From: Sue Howell
Sent: 12 June 2014 15:38
To: Planning.Responses
Cc: Peter Cleveland
Subject: RE: Planning Consultation on: LU/117/14/RES

Comment from Greenspace

APPLICATION LU/117/14/RES
NO:
Registered: 12th May
2014
Site Address: Land at The Poplars Littlehampton BN17 3PS
Grid Reference: 503985 103343
Description of Works: Application for approval of reserved matters following a grant of outling planning permission LU/203/13/ for landscaping.

SITE LAYOUT PLAN

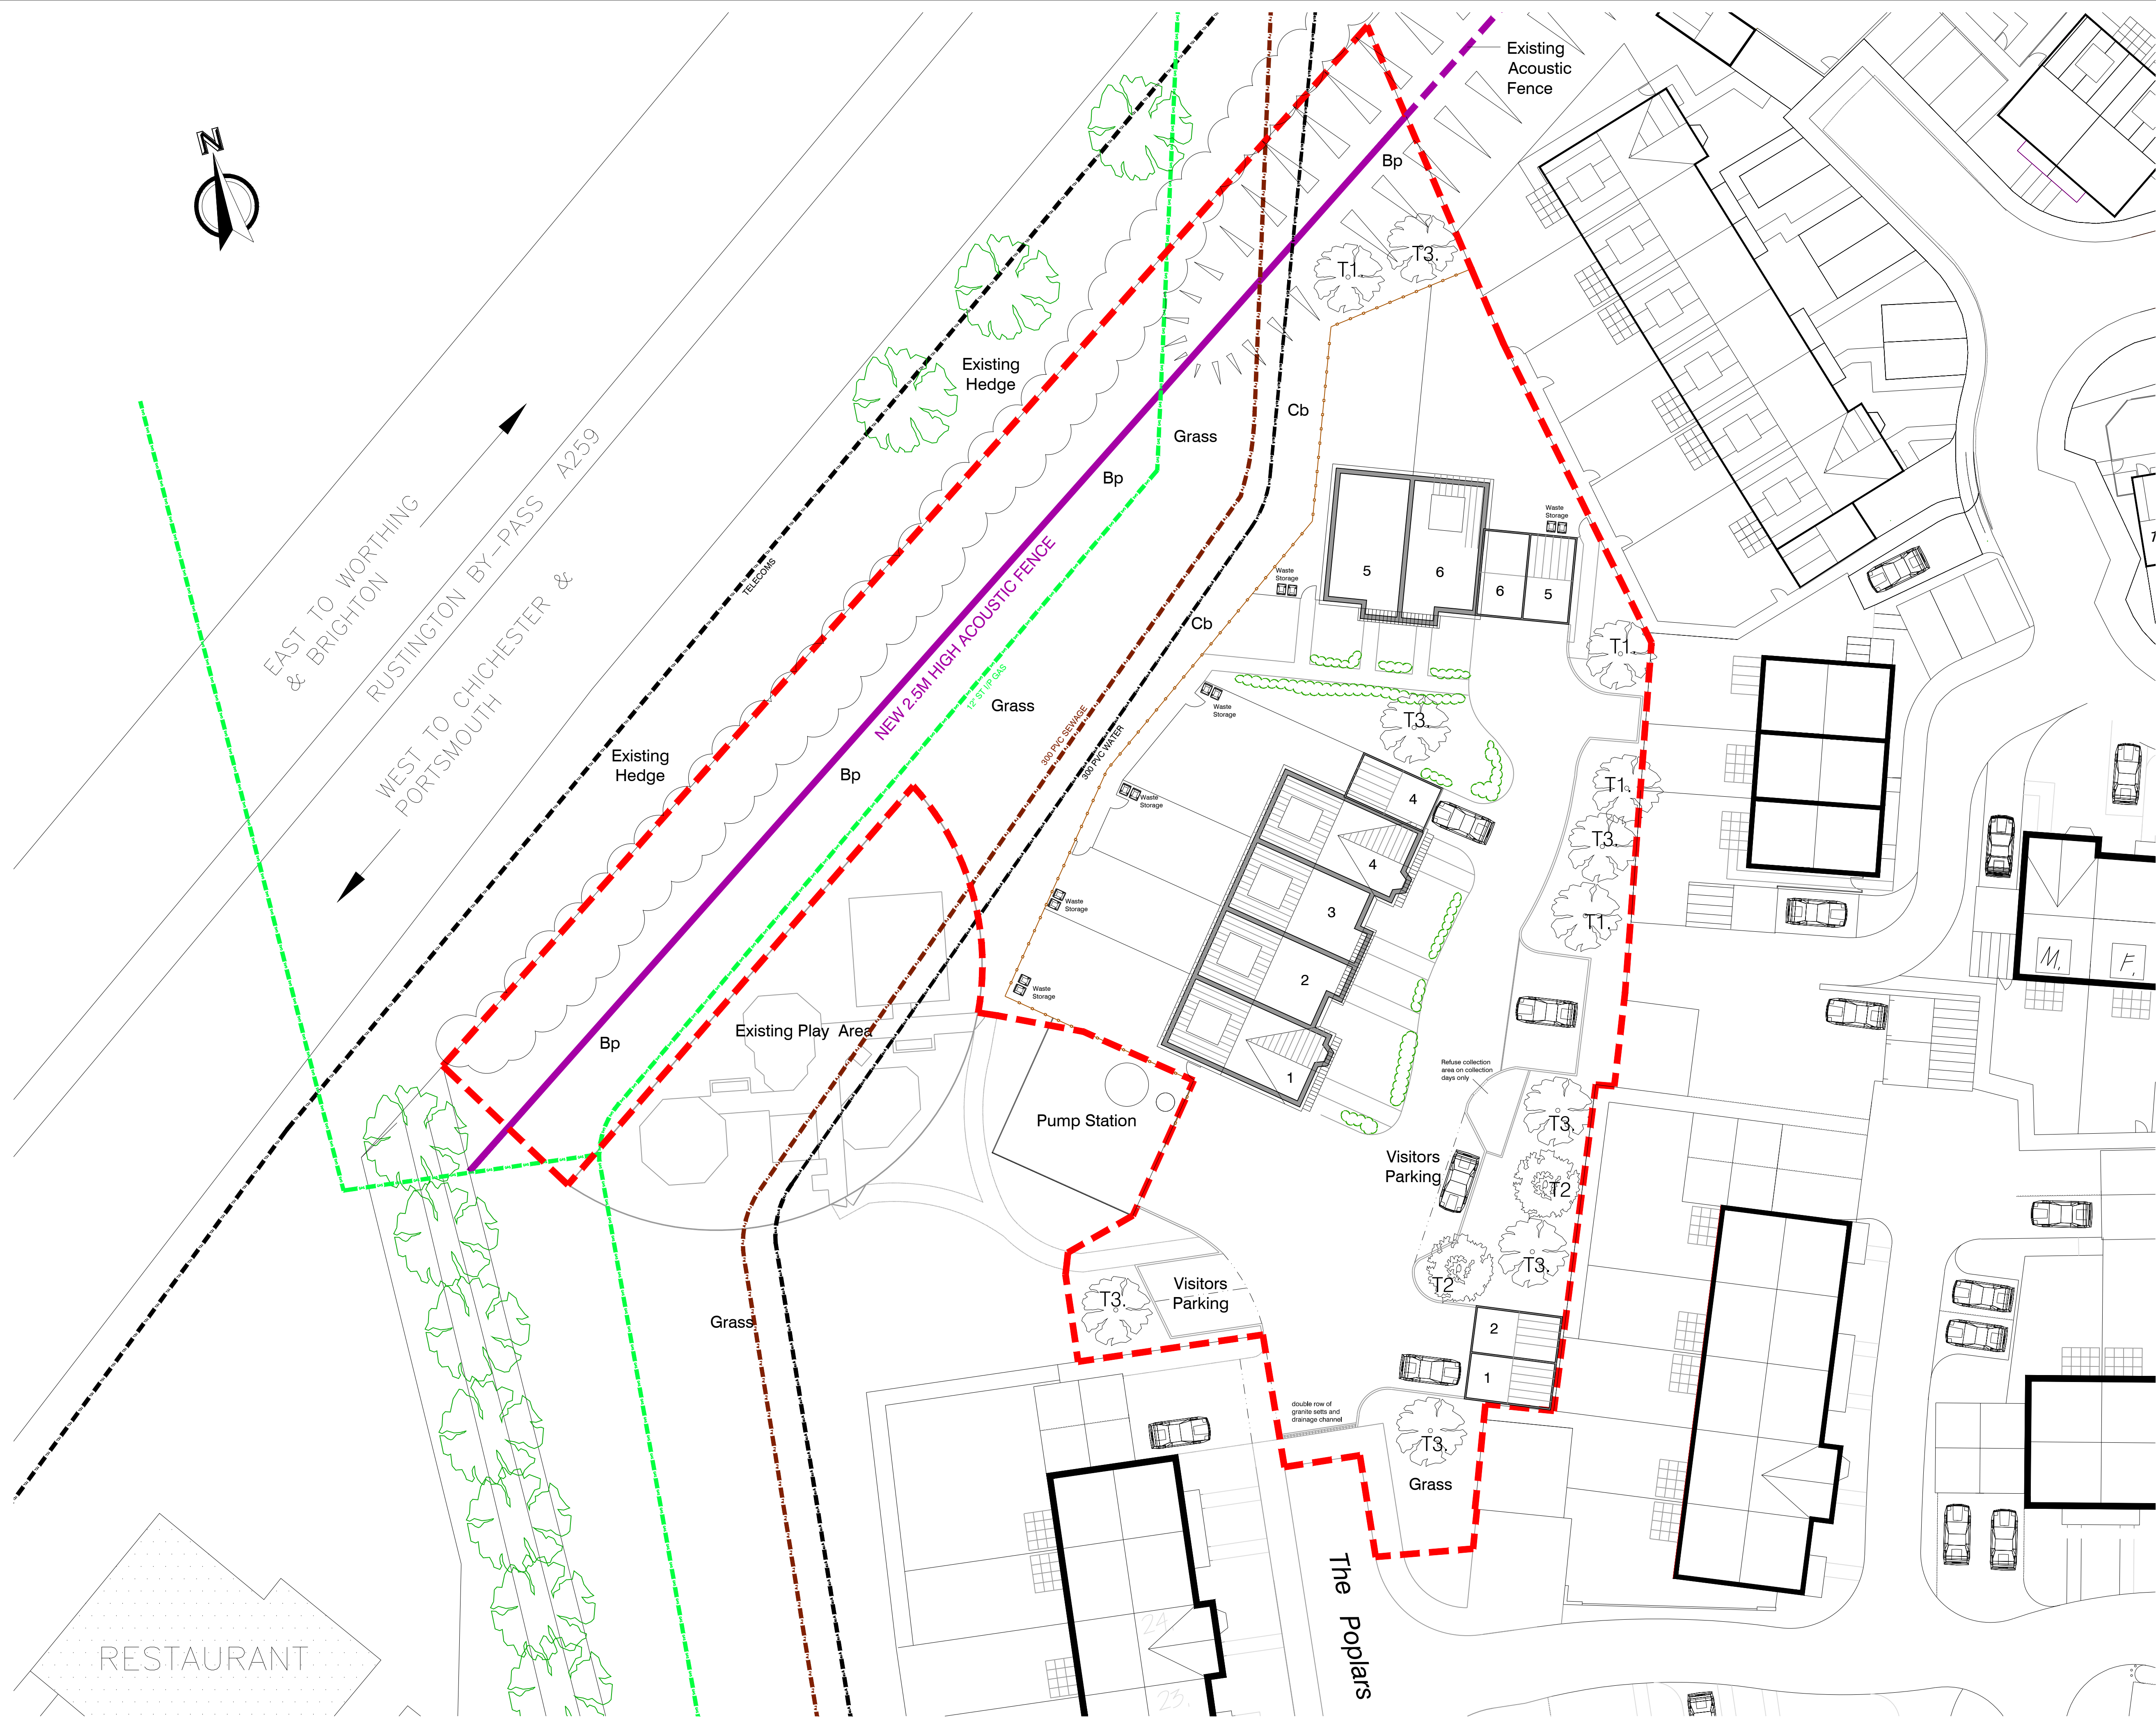
Condition 1 of this reserved matter application, the general tree detail re species choice, sizes and location of planting we feel is adequate for the location in that over time it will form a screen between the existing development and that proposed. The tree species chosen are a medium life-span tree, which do not display too dense a crown structure at maturity. We would however request a planting detail/cross section to substantiate how these are to be planted and the protection measures in place to ensure that they do establish, thrive and develop to the screen suggested. We would not recommend our approval of **Condition 1** until this information has been submitted and approved.

DETAILS SUBMITTED TO DISCHARGE CONDITION 9 UNDER LU/203/13 – THE POPLARS, LITTLEHAMPTON

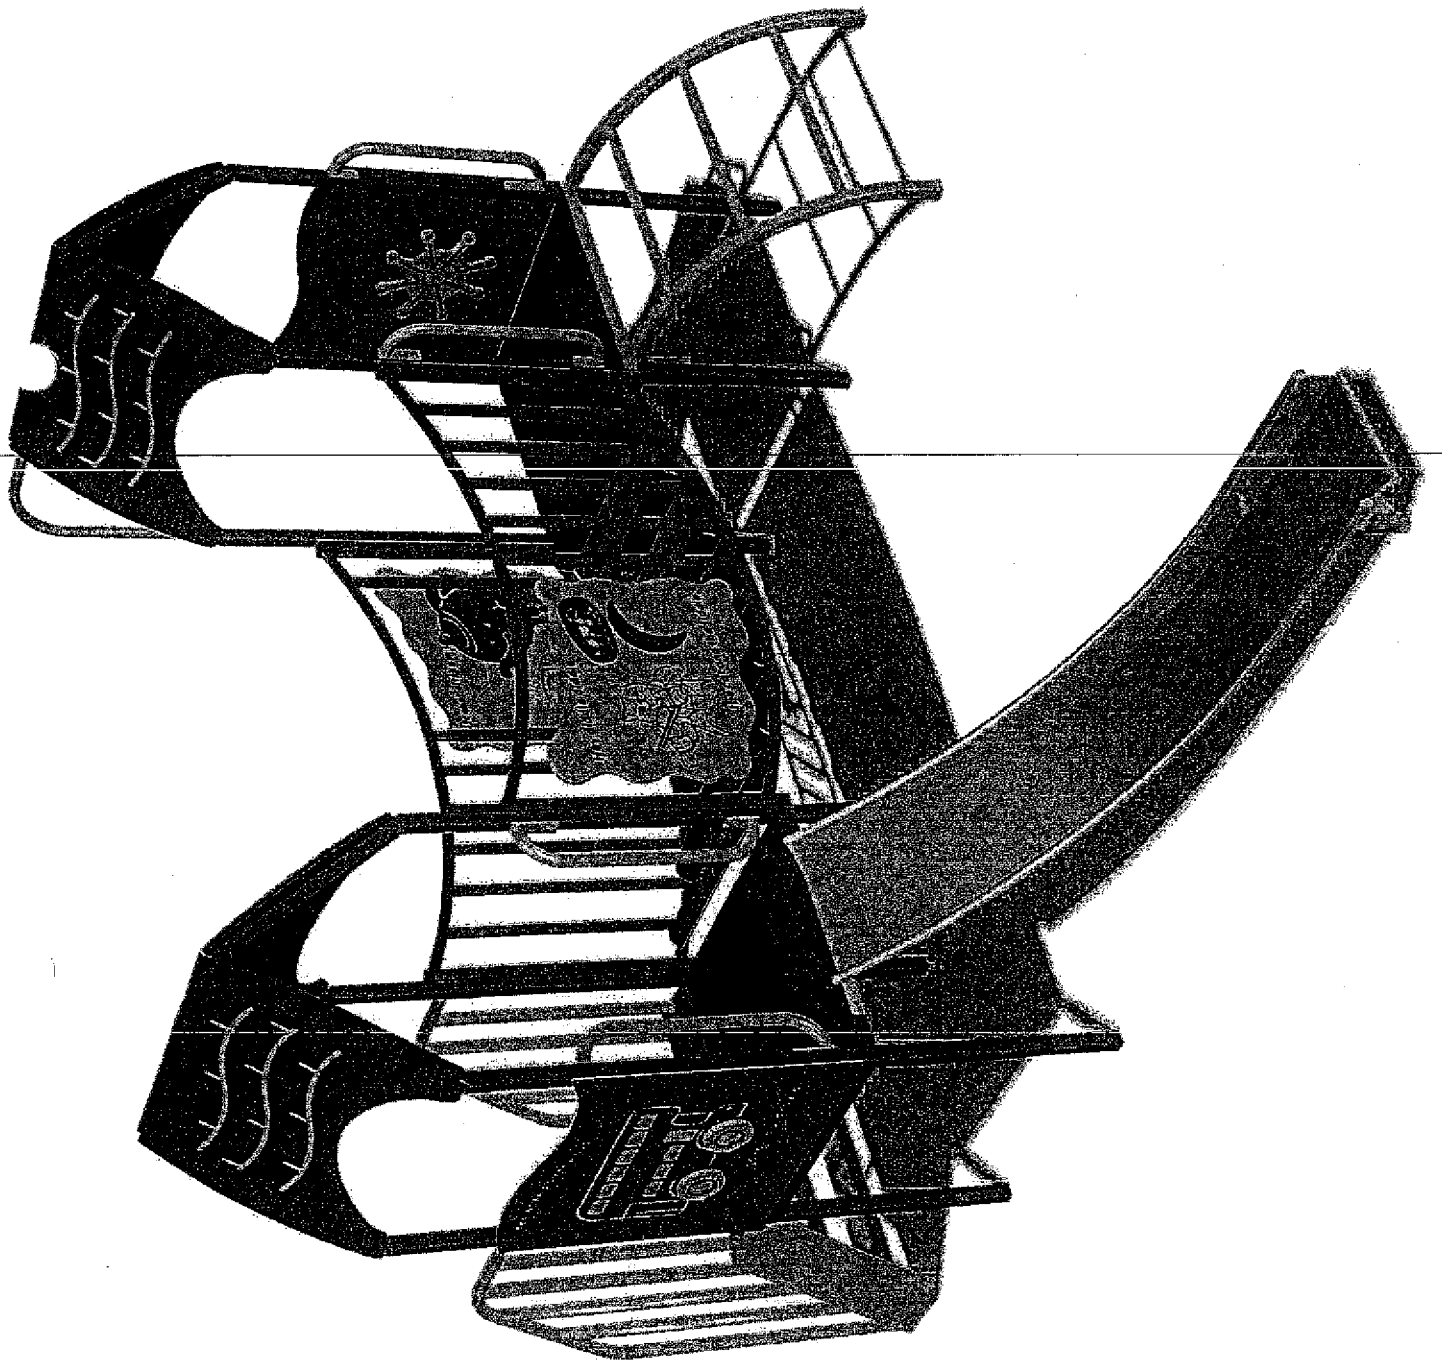
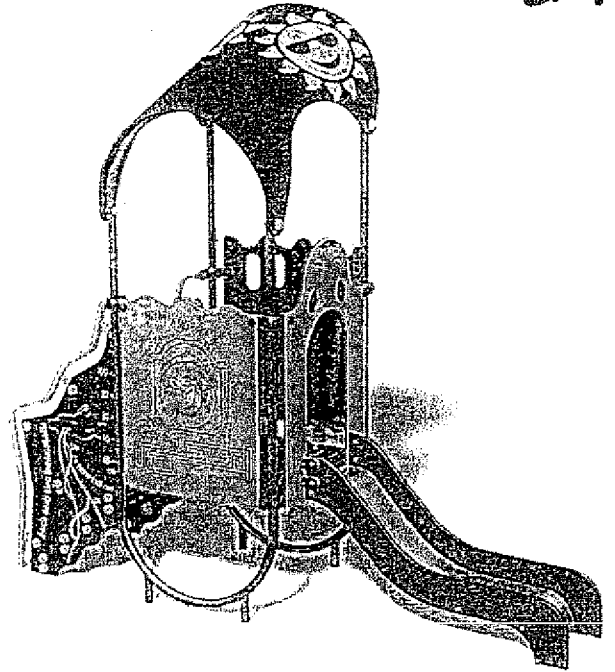
Condition 9 regarding the approval of the improvements of play equipment to the existing play area. The information submitted is sufficient and suitable for location and therefore does allow us to recommend the discharge of **Condition 9** of this application.
